Recommendation Report for Planning Permission

REF NO: AL/88/18/PL

LOCATION: Aldingbourne Cottage Rest Home
Westergate Street
Westergate
PO20 3QR

PROPOSAL: Two storey side extension.

ROOF PLAN

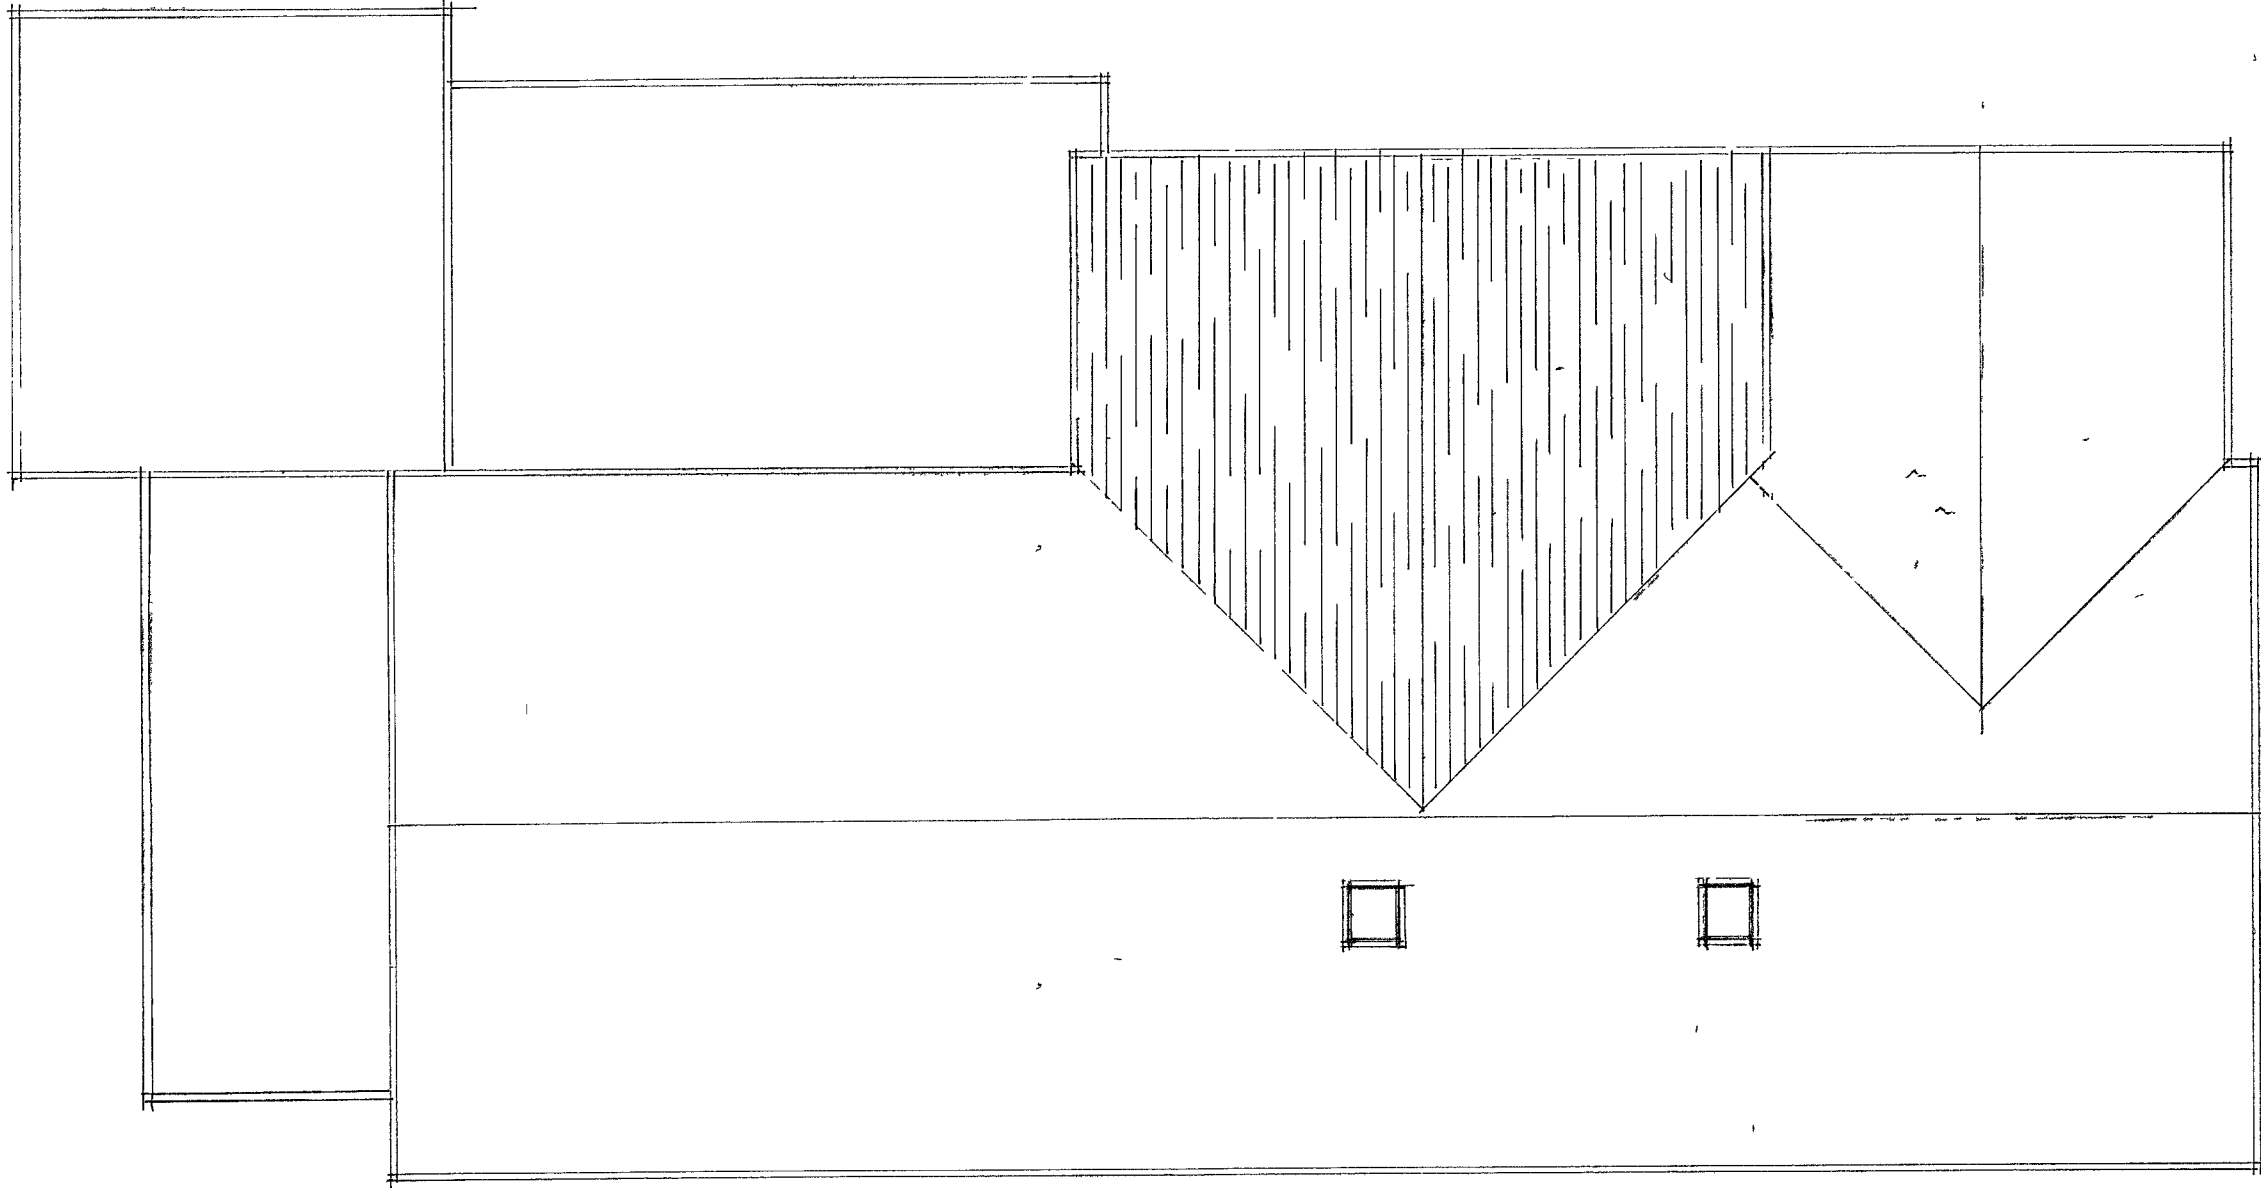
2 rooflights are proposed within the roofslope facing the properties along Old School Place. The rooflights would serve 2 bedrooms. From an assesment it is considered that they would not lead to any detrimental overlooking toward the properties along Old School Place. It is considered that no detrimental overlooking would occur to occupiers of adjoining properties.

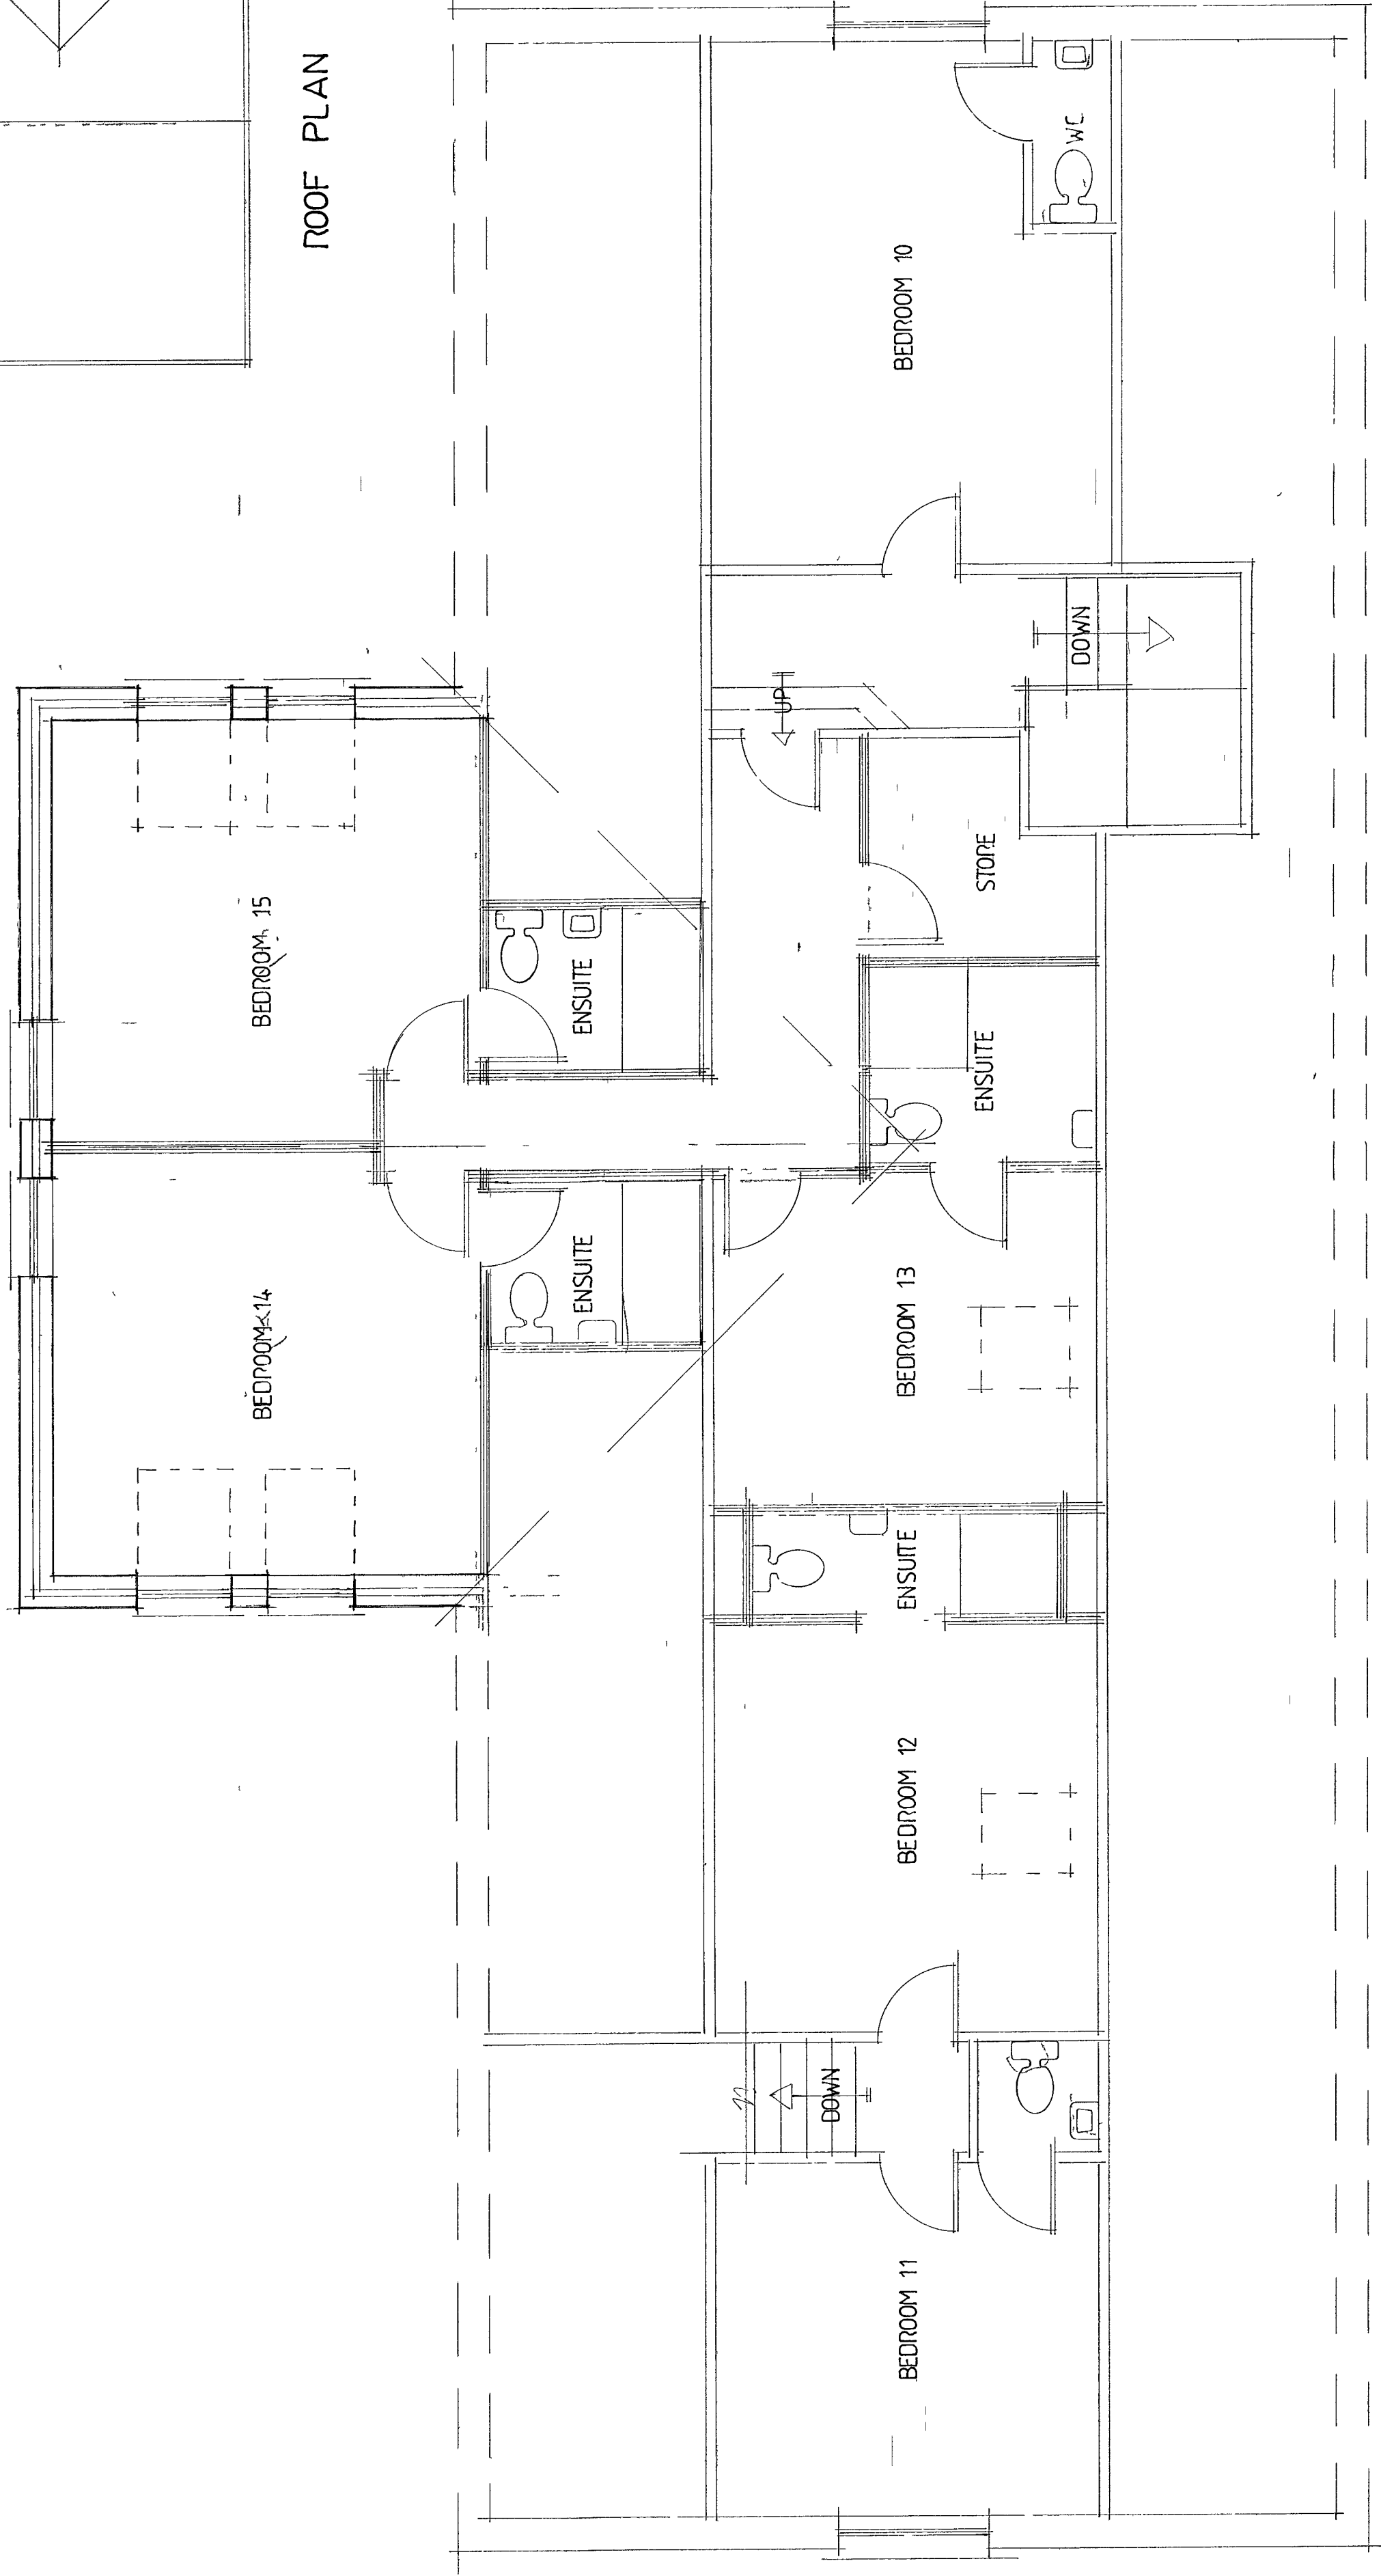
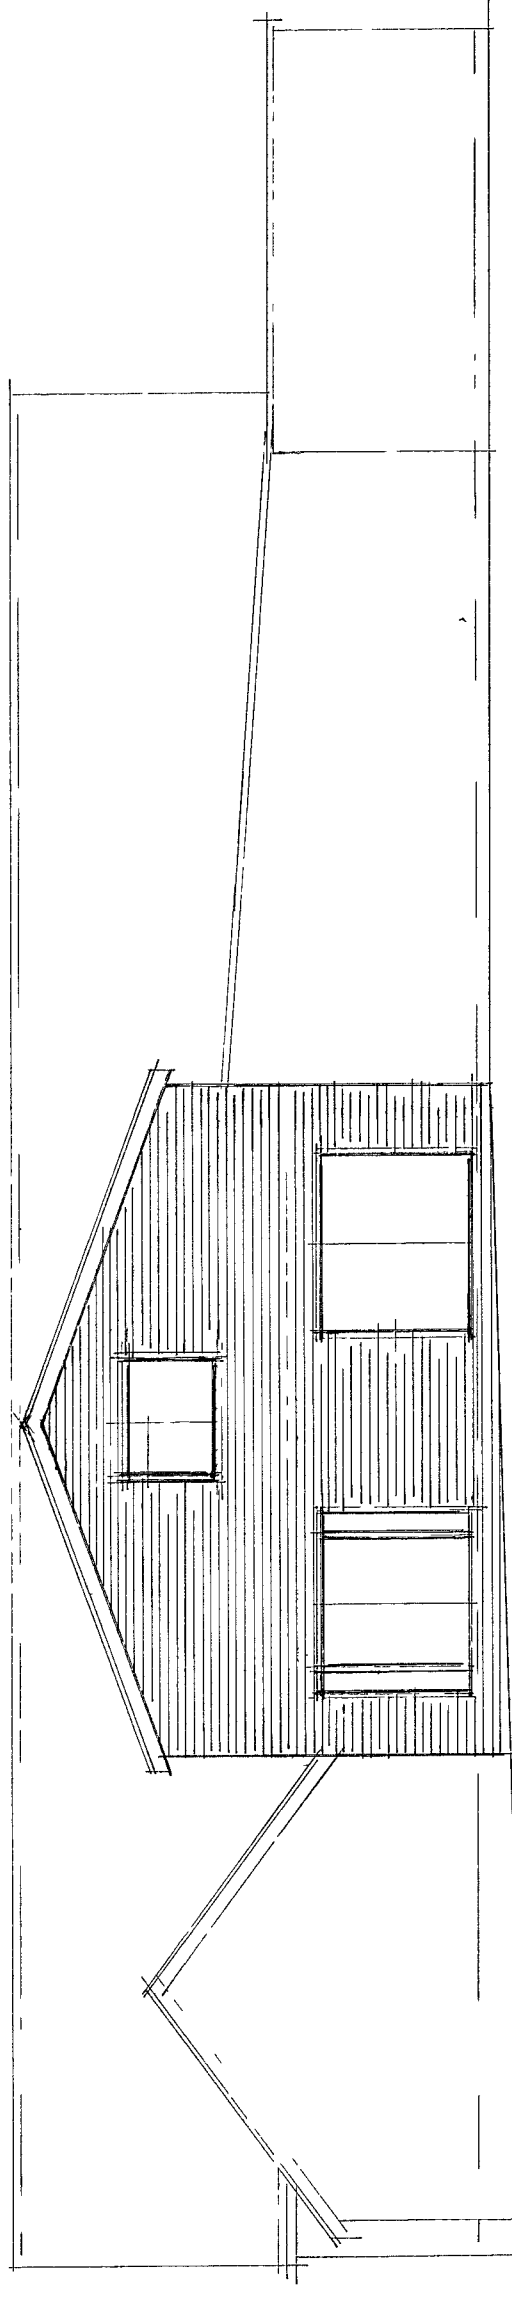
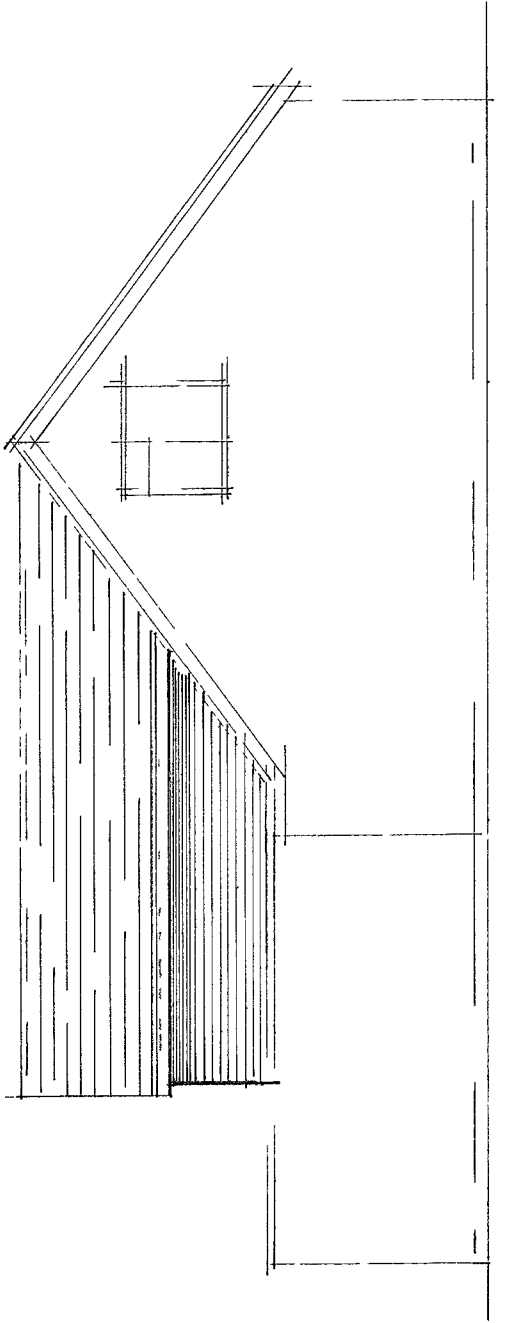
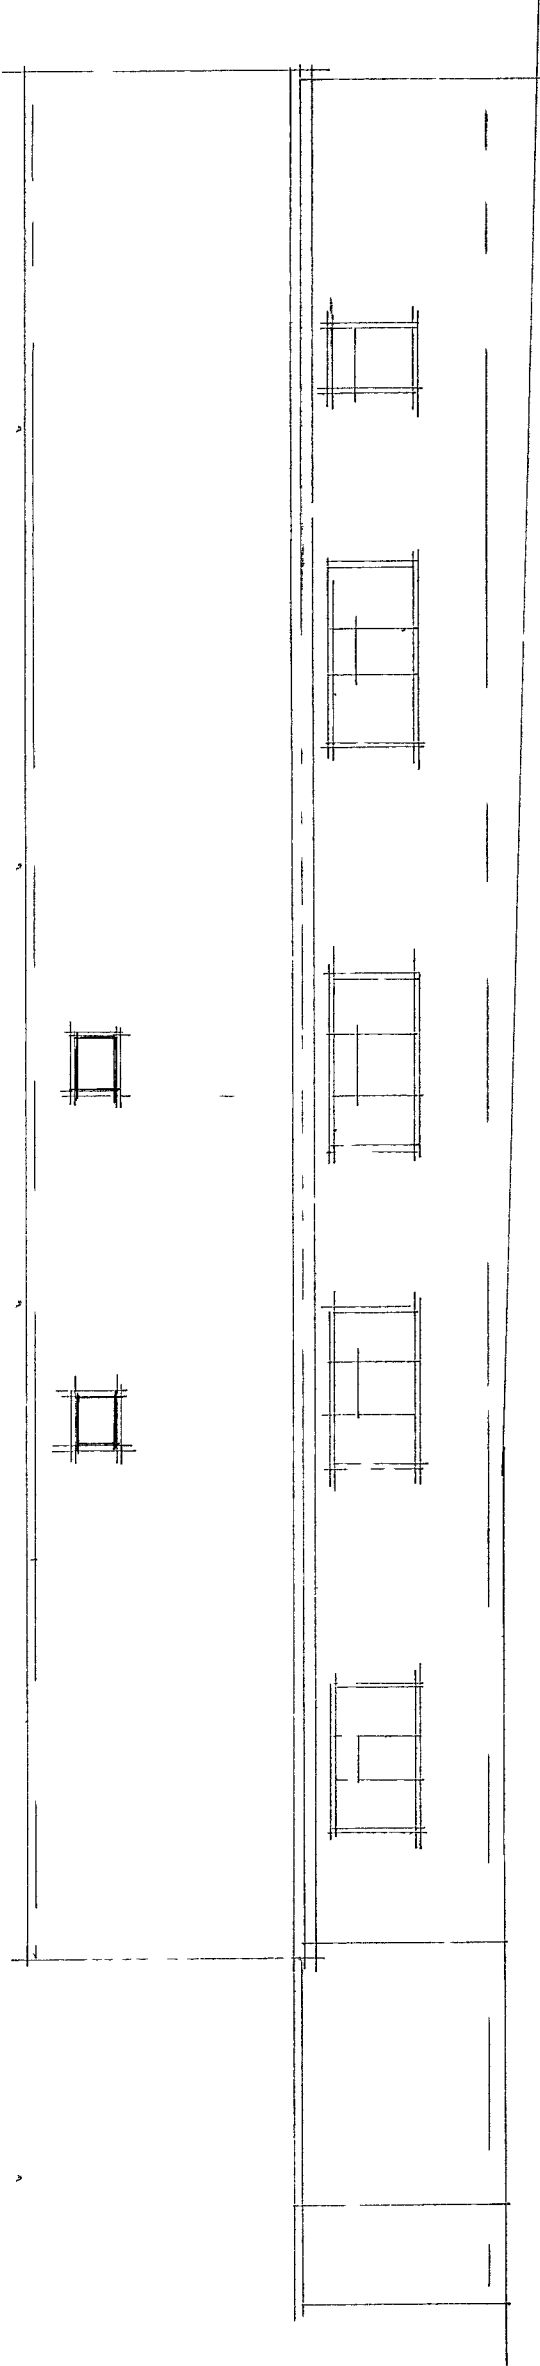
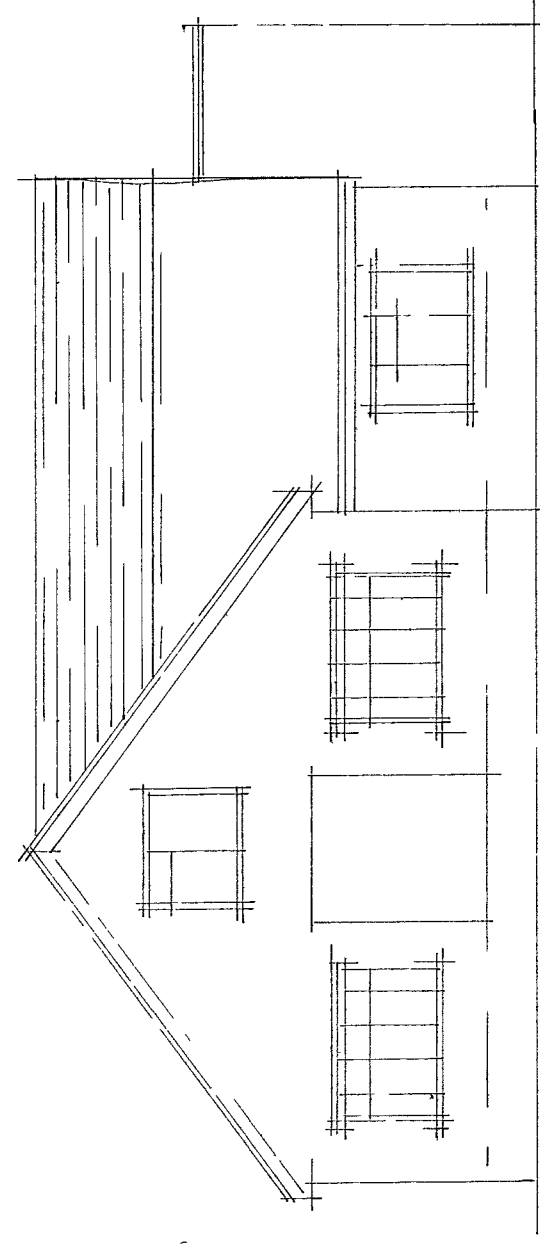
Officers note the properties along Elmcroft Place and that they have windows that look out toward the care home. There was concern with these properties being overlook, particularly into the bedroom window of adjoining property number 5 Elmcroft Place. As such, amended plans have been received which show the windows at first floor would be obscurely glazed. Therefore with appropriate and reasonable conditions it is considered that no detrimental overlooking would occur to the occupiers of adjoining properties along Elmcroft Place, with particular regard to number 5.

The proposal would also include windows in the side roof slopes/side elevations. Limited views would be available toward Westergate street due to the existing pitched roof rear projection providing a level of screening. Any views from these windows out toward the properties opposite, along Elmcroft Place would be at an angle such that views would be limited. One of the windows in the roof slopes/side elevations would allow views toward adjoining property number 9. While views would be available out toward the rear garden of number 9 it is considered that they would be at an angle and limited over a distance of over 17 metres. Additionally Officers note the window at first floor in the side elevation of adjoining property number 9, but do not consider that detrimental over looking sufficient to warrant a refusal would occur toward this window as a result.

- 6 The windows at first floor, in the proposed extension hereby granted, facing the properties along Elmcroft Place shall be obscurely glazed to a height of 1.7 metres from the floor of the room they serve and shall be maintained as such in perpetuity.
